# CITY OF ALBUQUERQUE

PLANNING DEPARTMENT – Development Review Services

December 30, 2016

**RE: Sotogrande Housing  
Conceptual Grading and Drainage Plan  
Engineer's Stamp Date 12-6-2016 (File: M15D23H)**

CONCEPTUAL GRADING PLAN - NORTH HALF
SCALE: 1" = 30'

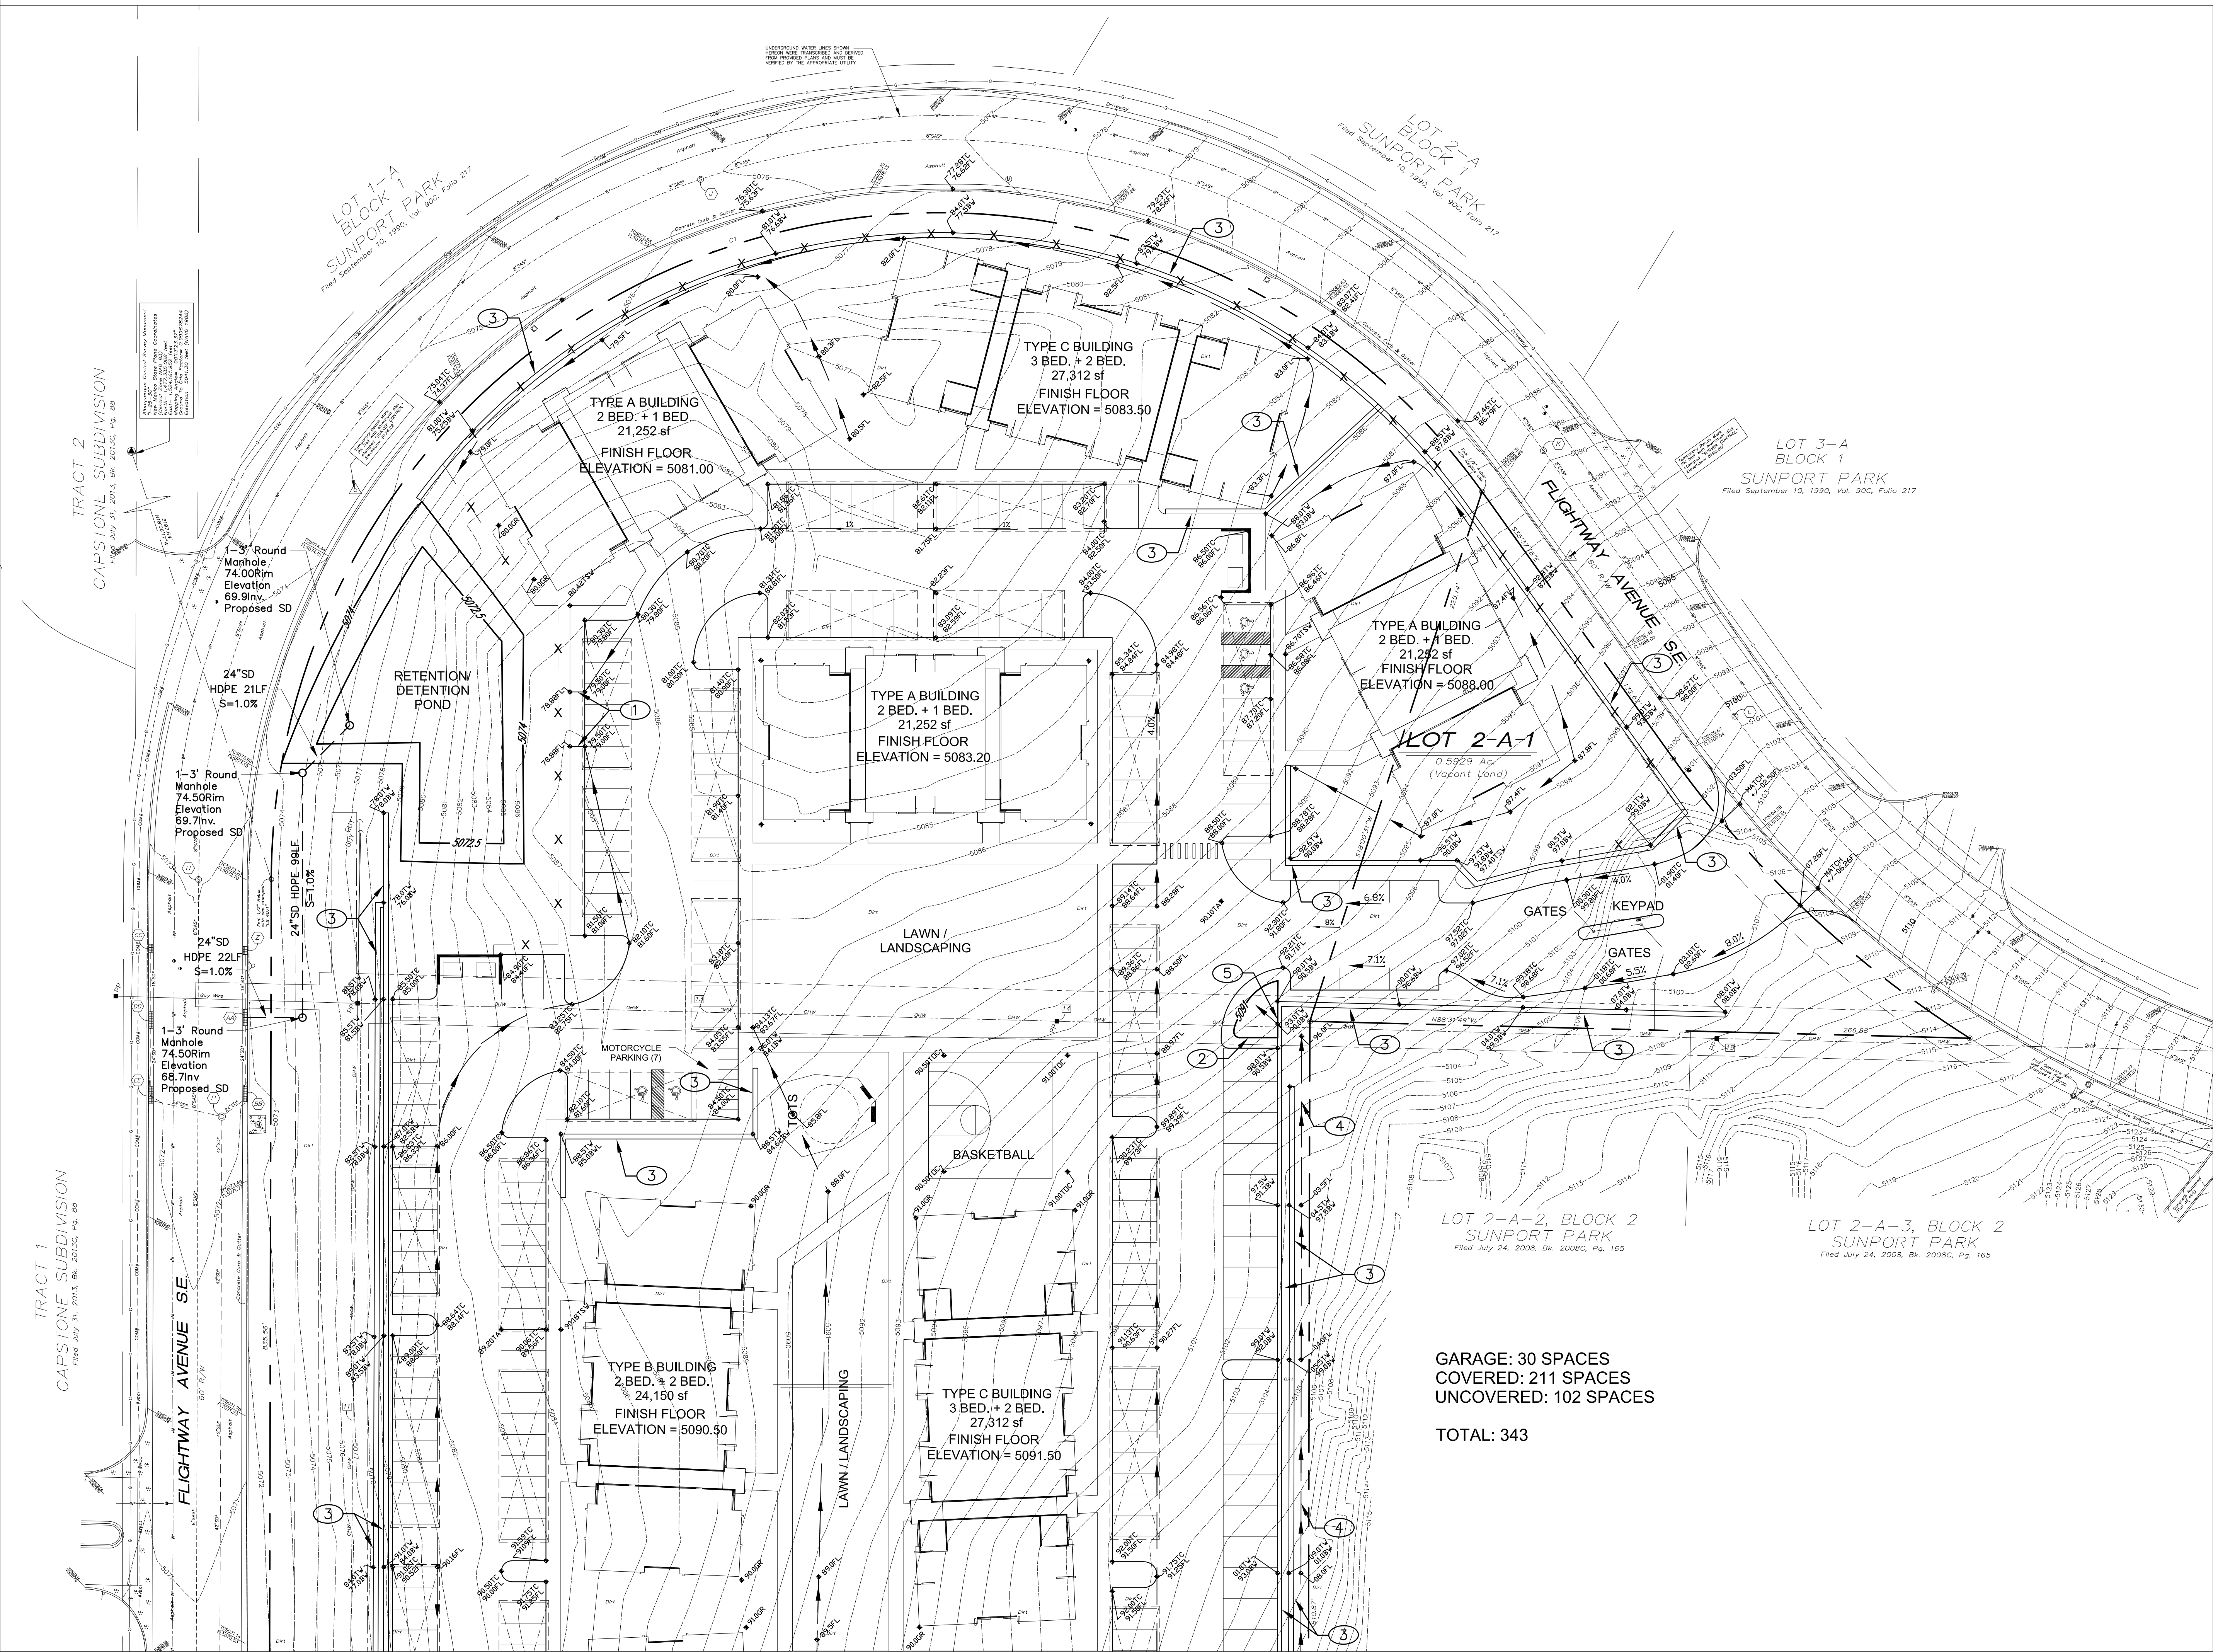
1. Provide Benchmark.
2. The project is large enough that the plan needs to show the design elements developed beyond a conceptual site sketch for Grading Permit Approval. For example, no curb ramps are shown, and it is not clear if the line type used for curbing is the back, or flowline of the curb. Side walk beginning and ends are not defined.

3. Provide a cross section for the offsite flow swales.
4. Provide information and build notes for the driveways (curb, ramps, slopes, limits of side walk construction, valley gutter).

5. Should propose an inlet vs a manhole or give detail if it is a specialty manhole (plastic, or other).
6. Show how roofs drain on the plan.
7. The area between back of curb and property line should be depressed or provided erosion control behind curb.

8. Is there an existing cross lot drainage easement on this property to accept flows from the adjacent lot?
9. If possible, the swale that outfalls to the wood ward Rd driveway should pass through a water Quality Pond just prior to the curb cut.

10. Storm Drain connections to the back of a public inlet must be completed through the SO-19 permit process. Please include the standard SO-19 Notes on the plan. The connection will need to reference and comply with Std. DWG 2237.

11. Clarify how the concrete channel referenced with keyed note #2 is to be constructed. It is missing information.

12. Provide details for the above mentioned concrete channel. Provide cross section of retaining wall segment as well.
13. Include the cross section of retaining walls referenced in keyed note #4.
14. The plan should show how roofs flow will be conveyed across the sidewalks that surround the buildings (sidewalk culvert or piping should be used).
